Application: SSI 7485

I write regarding the proposed modification to M4-M5 Link, Mod 2 The Crescent overpass and changes to pedestrian infrastructure in North Annandale, Rozelle and Rozelle Bay Foreshore area.

Figure 4-4 Elevation: Indicative view of The Crescent overpass

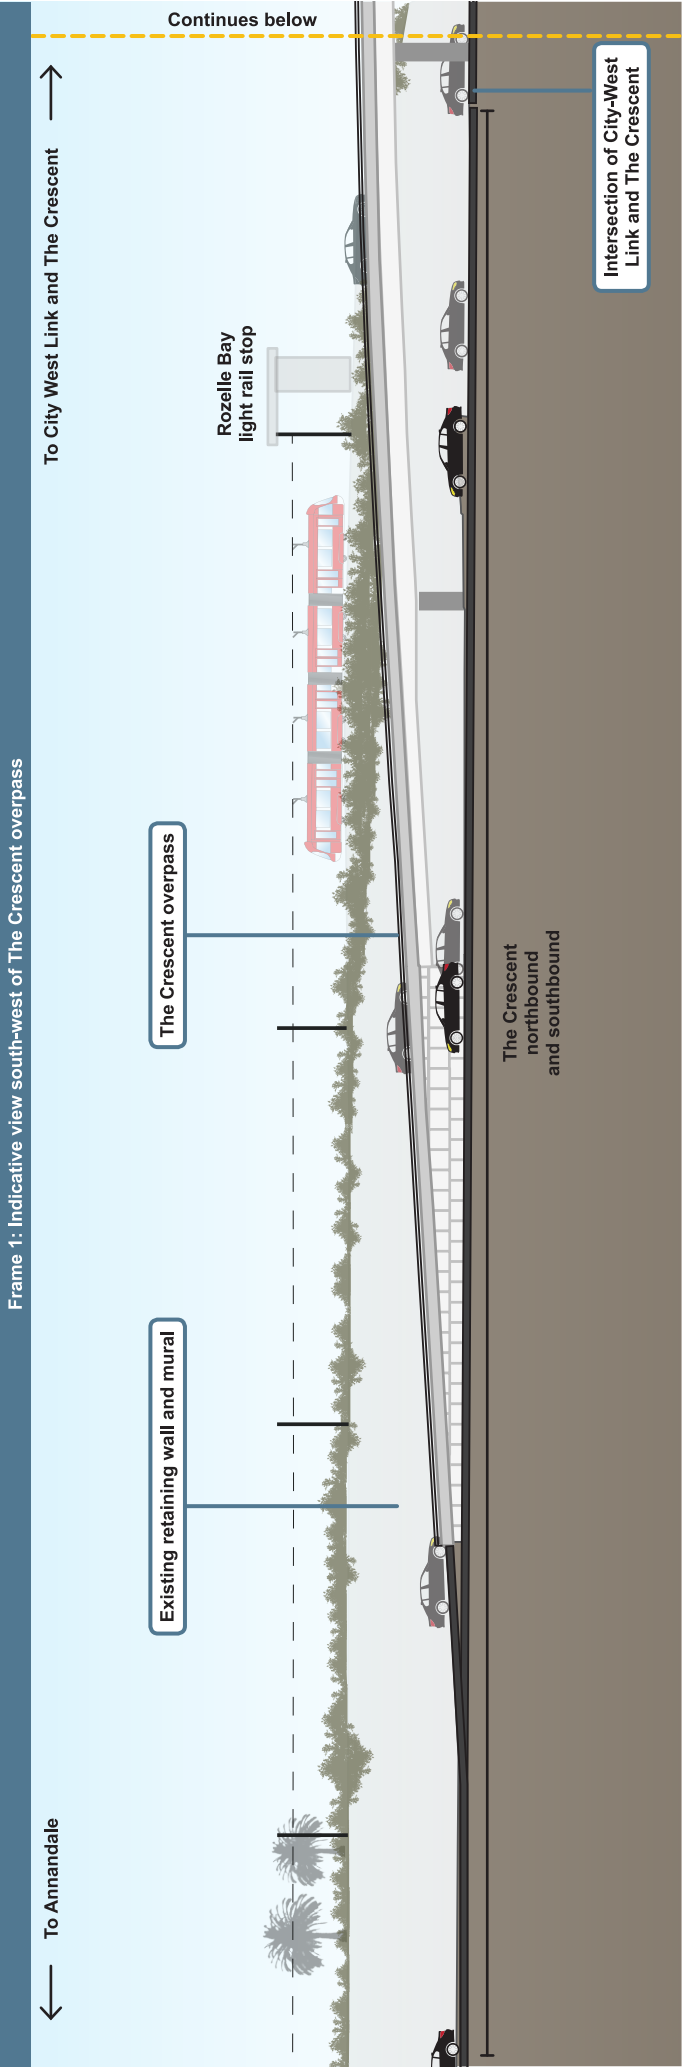
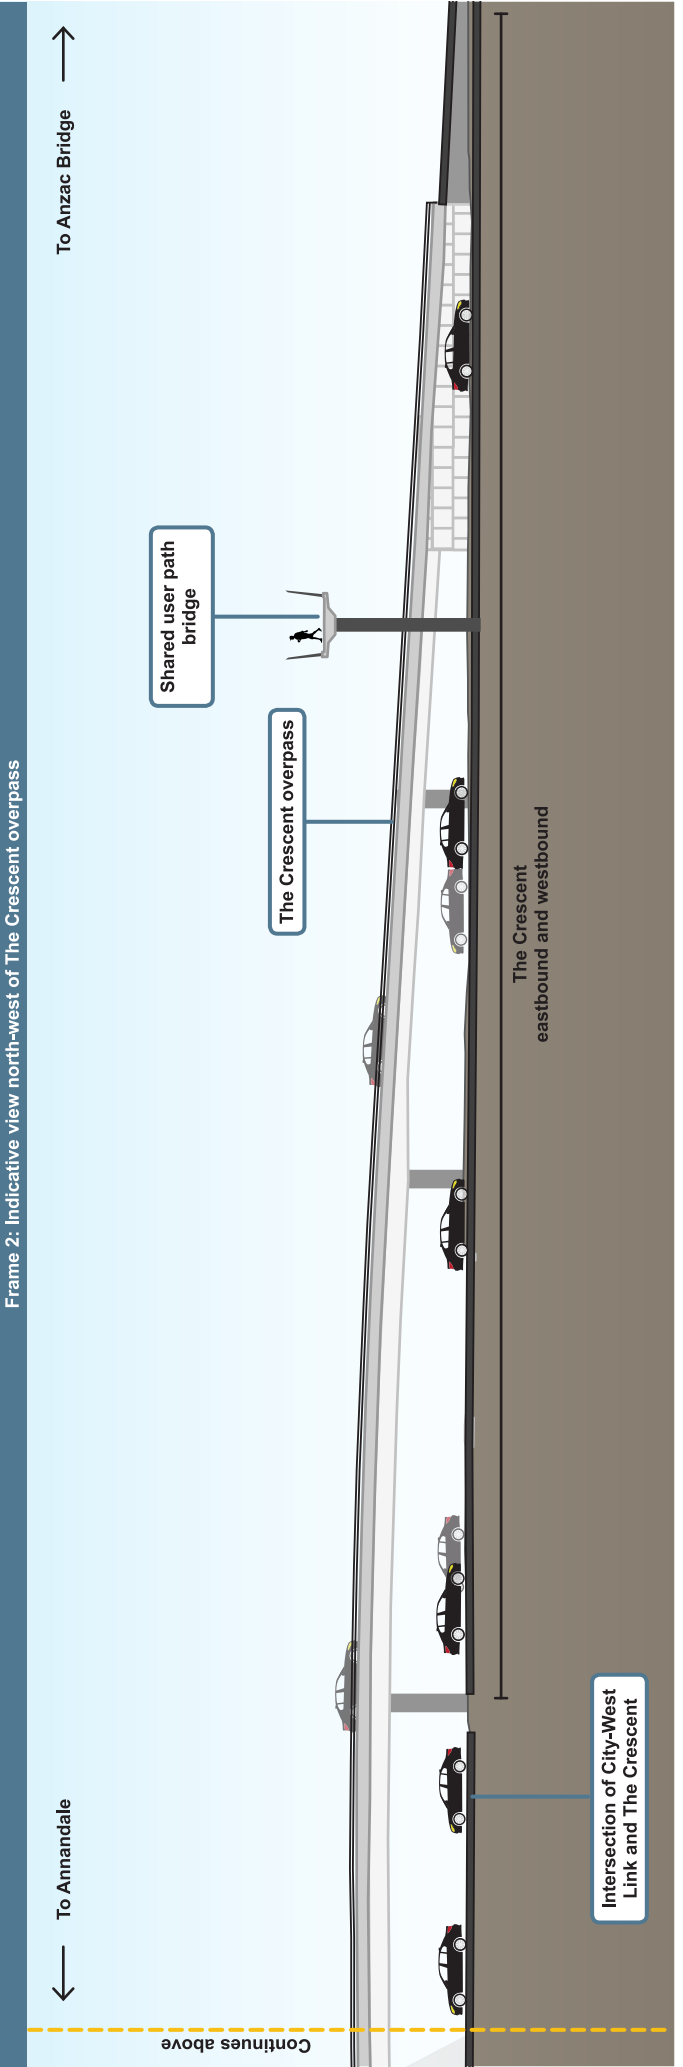
I request RMS work with the community to explore alternate design options to the proposed new car overpass design and the changed pedestrian and cyclist links. I am seeking the reinstatement of the safe, direct access from the approved EIS GreenLink to create a continuous green open space connection from the Rozelle Rail yards and Annandale to the foreshore. The GreenLink was more than just a walk way - it put people central to the design, maximising safety, and providing much needed accessible open space for the community now and into the future Bays Precinct design.

Figure 4-5 The Crescent/Johnston Street/Chapman Road intersection

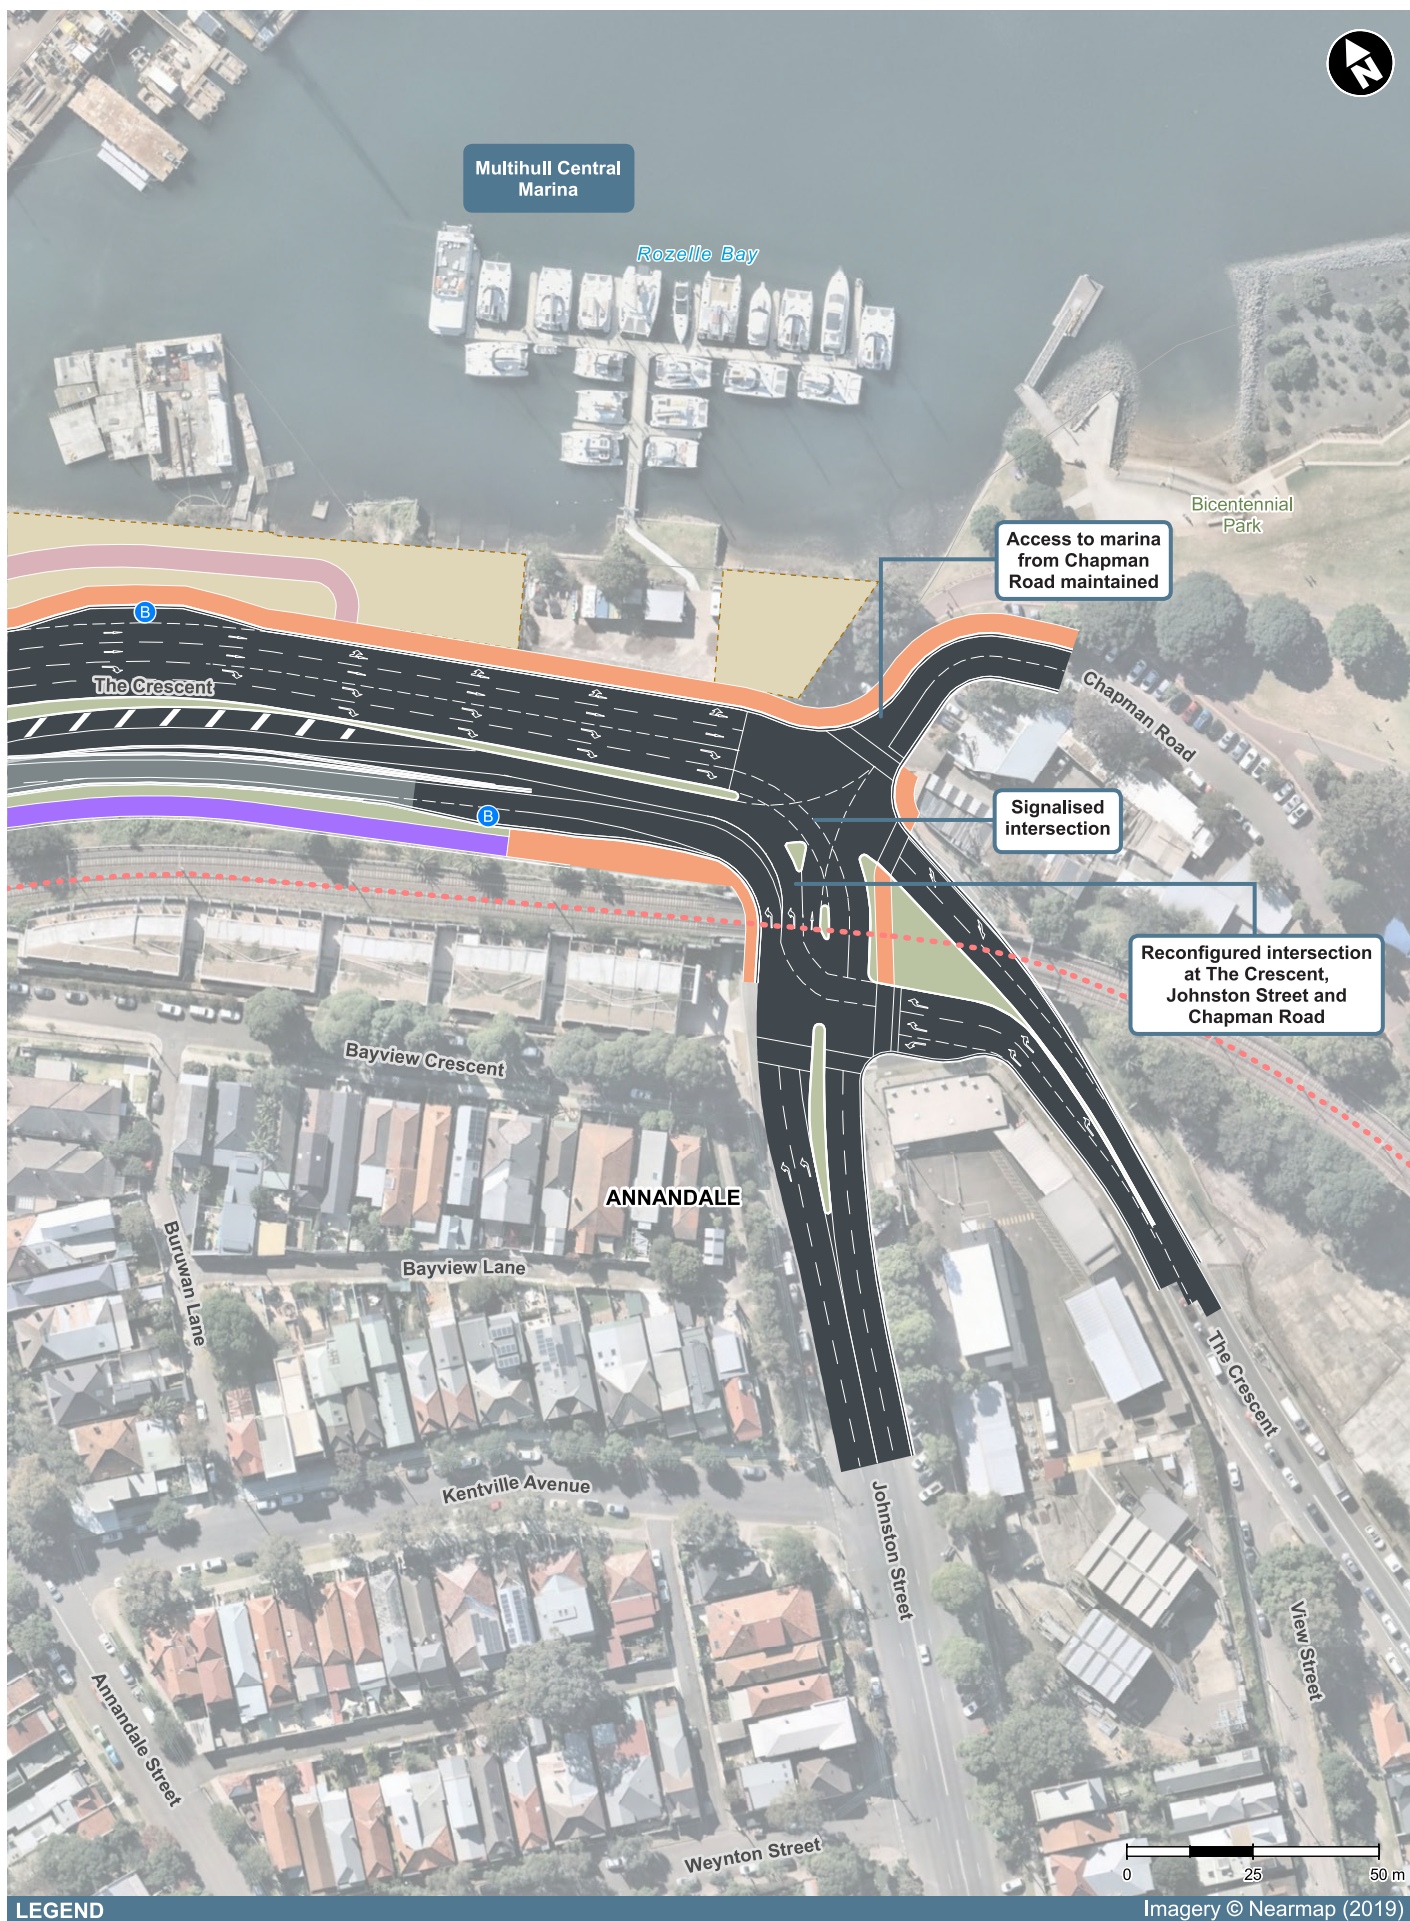
- The significantly reduced safety and increased risk for pedestrians and cyclists with removed access over The Crescent to Bicentennial Park and the increased traffic along Johnson Street.
- Being required to cross five sets of pedestrian lights at The Crescent as my option to reach the foreshore from Annandale or from Rozelle light rail stop.
- Removal of direct active links to the foreshore, cutting the community off from the area and the proposed revitalisation of the entire Bays Precinct, including linking the Light Rail and Bus stops to a Ferry wharf and Metro station.
- Urban and landscape design that is being built before a finalised Masterplan for the area.
- Traffic changes that limit movements around the suburb and create further congestion in the local streets of Annandale, Forest Lodge, Glebe, Lilyfield and Rozelle with no planning to deal with these.

Figure 4-6 Elevation: Indicative view of Rozelle Rail Yards Pedestrian and Cycling Green Link

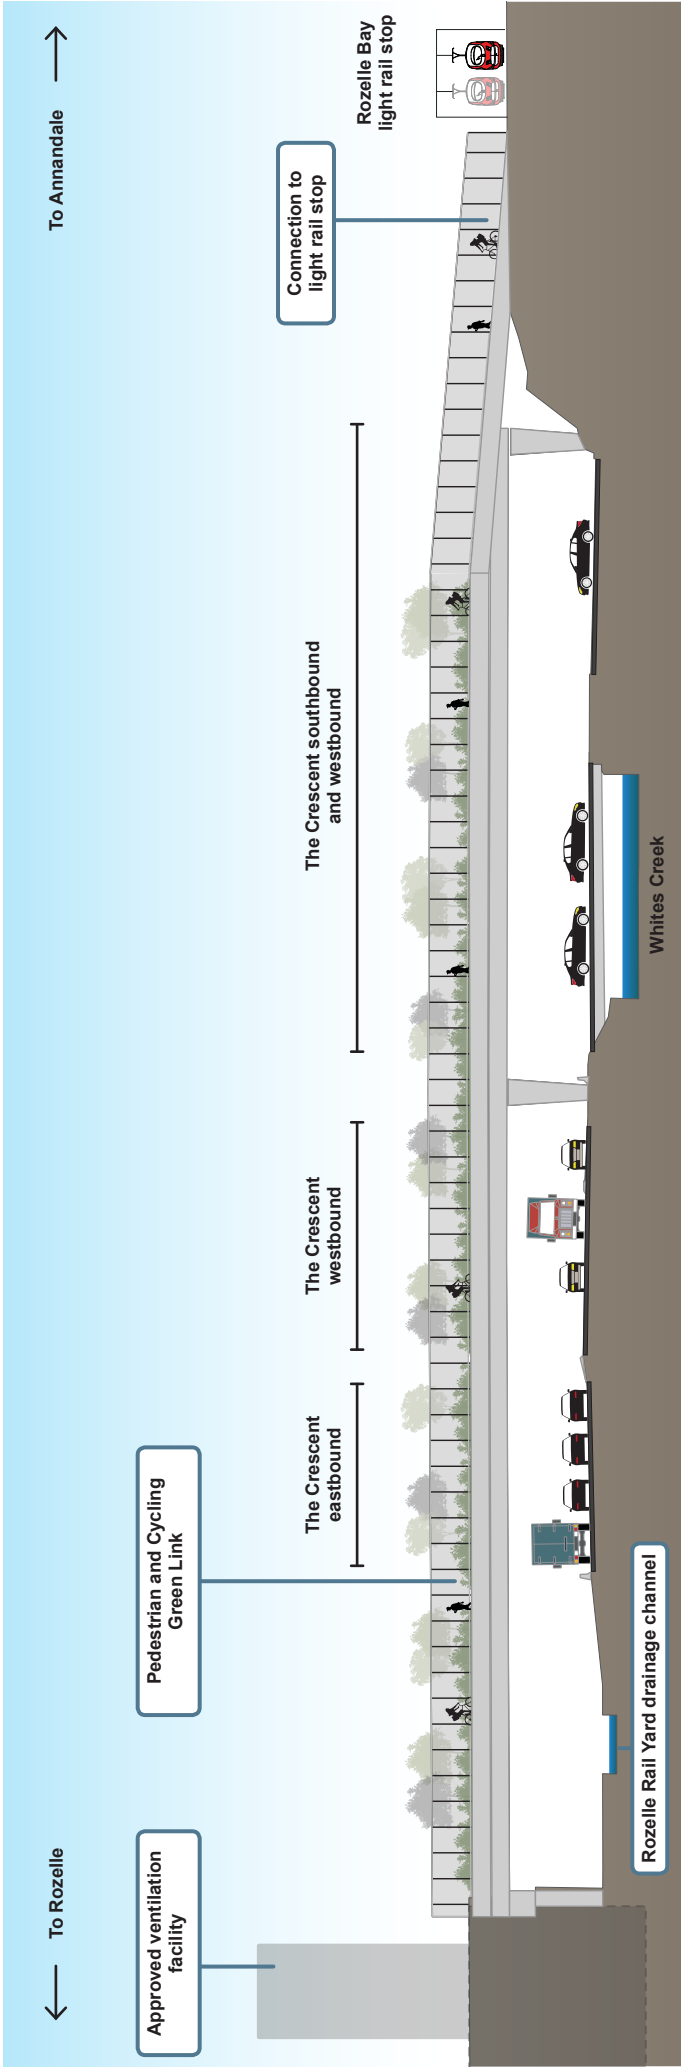
- Reinststate the GreenLink connecting communities and green open space from Rozelle to Bicentennial Park.
- Relocate and design pedestrian and cyclist connections that are continuous, safe and direct.
- Design the modification infrastructure and active links in response to the character of the suburbs, the location of the foreshore and it's potential future development.
- Provide pedestrian and cyclist paths that maximise people safety and do not force us onto busier streets, unsafe concrete plazas and caged walkways.
- Integrate active and direct connections to all active transport – including the future Metro West and Foreshore Ferry Wharf.
